WELWYN HATFIELD COUNCIL – DEVELOPMENT CONTROL
DELEGATED REPORT

APPLICATION No:	S6/2011/1683/LUP
------------------------	-------------------------

The proposal seeks a certificate of lawfulness for a rear garden room above an existing brick sub-structure.

PROPOSED

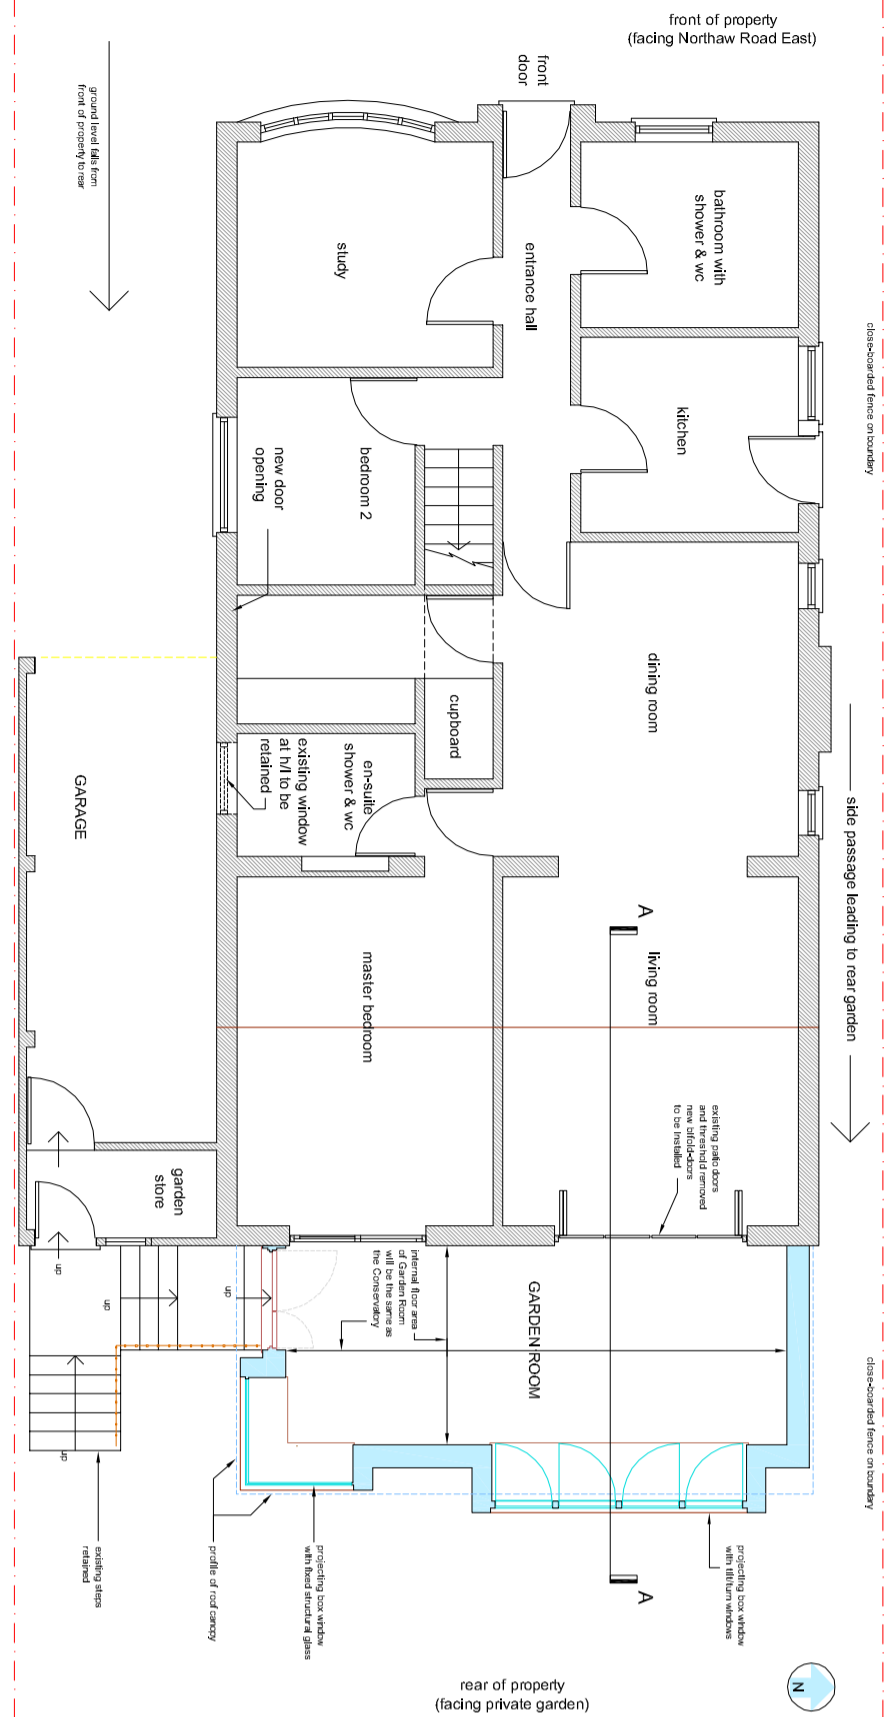
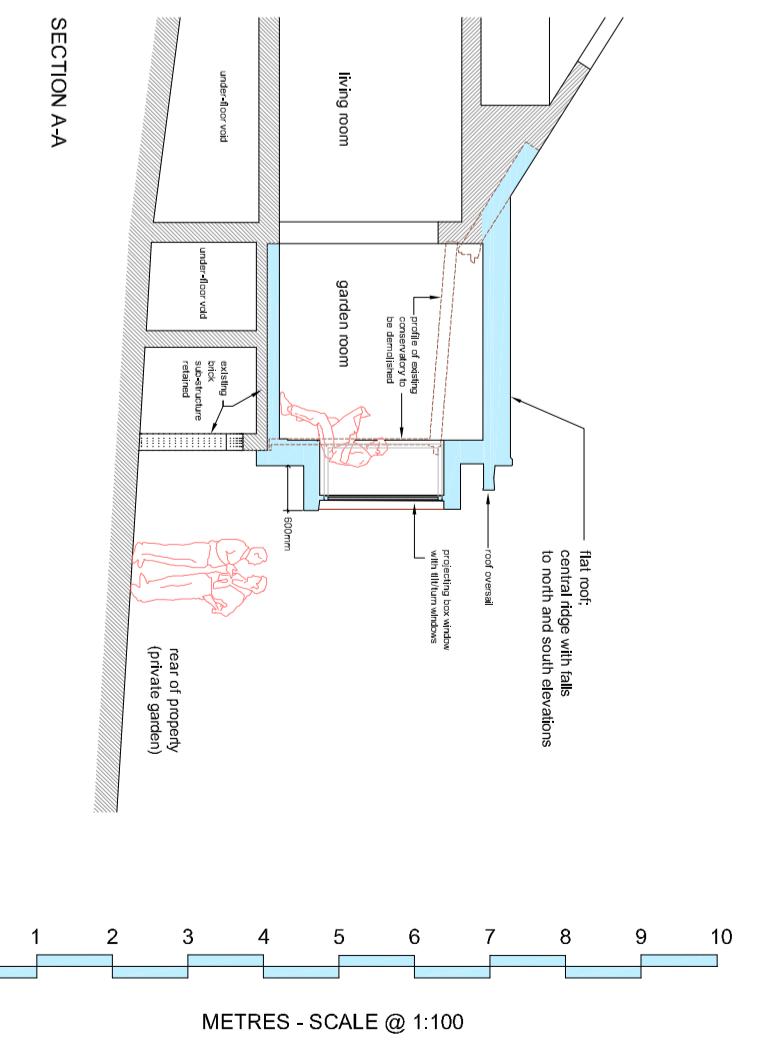
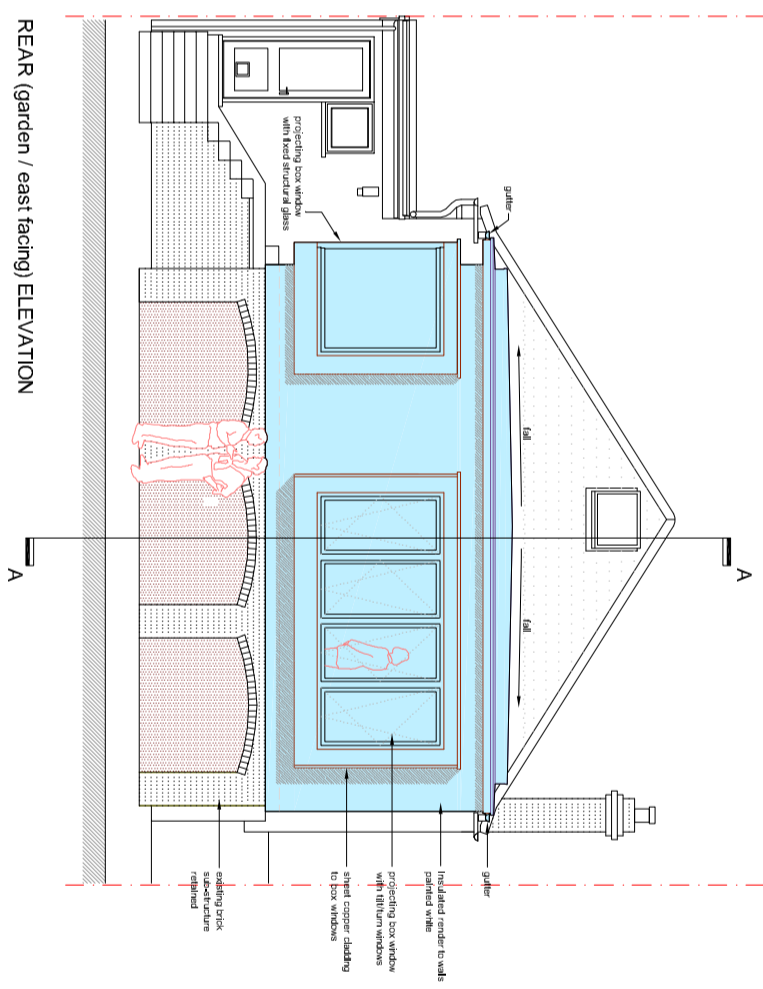
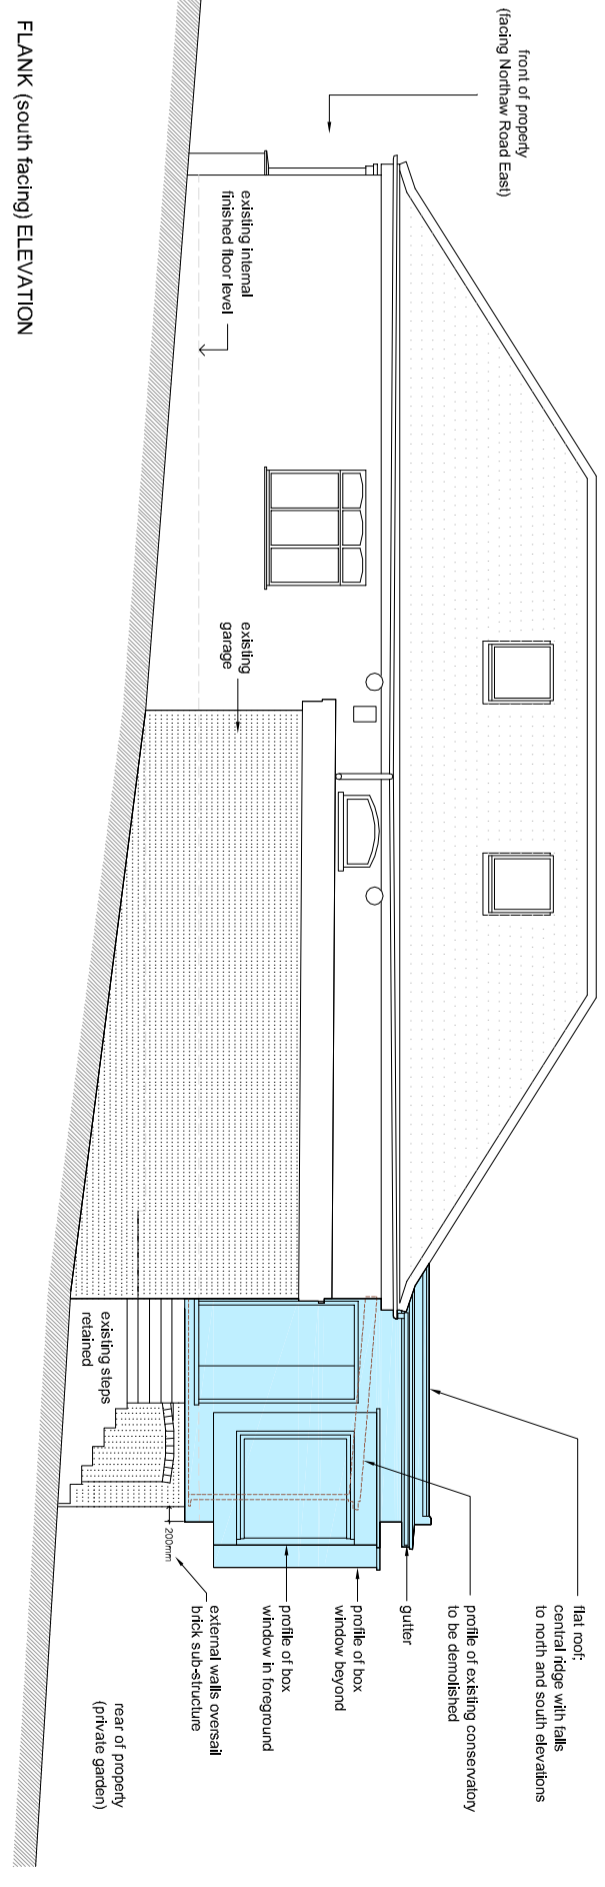
The proposal will extend above an existing sub-structure which was constructed due to the sloping land levels towards the rear of the property. The sub structure is

accessible and whilst it is not head room height, the proposal could be converted as habitable space. Therefore, the proposal should be considered as a two storey development rather than single storey.

The rear wall beyond which the proposed garden room will extend is not original as the dwelling was extended by approximately 4.9 metres under planning application, ref: S6/1985/0698. The proposed garden room in addition to the previous extension will accumulate in an extension which measures approximately 8.4 metres in depth from the rear wall of the original dwellinghouse.

The proposal measures less than 1 metre from the boundary with adjoining dwelling to the north, No. 29 Northaw Road East and the eaves height of the proposal would measure 4.9 metres. The proposal therefore fails to comply with part (g)

As the proposal is considered two storey the proposed windows forming the side elevations of the garden room. The plans have not indicated that they will be obscured glazed and non opening below 1.7m. However this is a condition attached and applicable to any approval and must be complied with in order to be lawful.
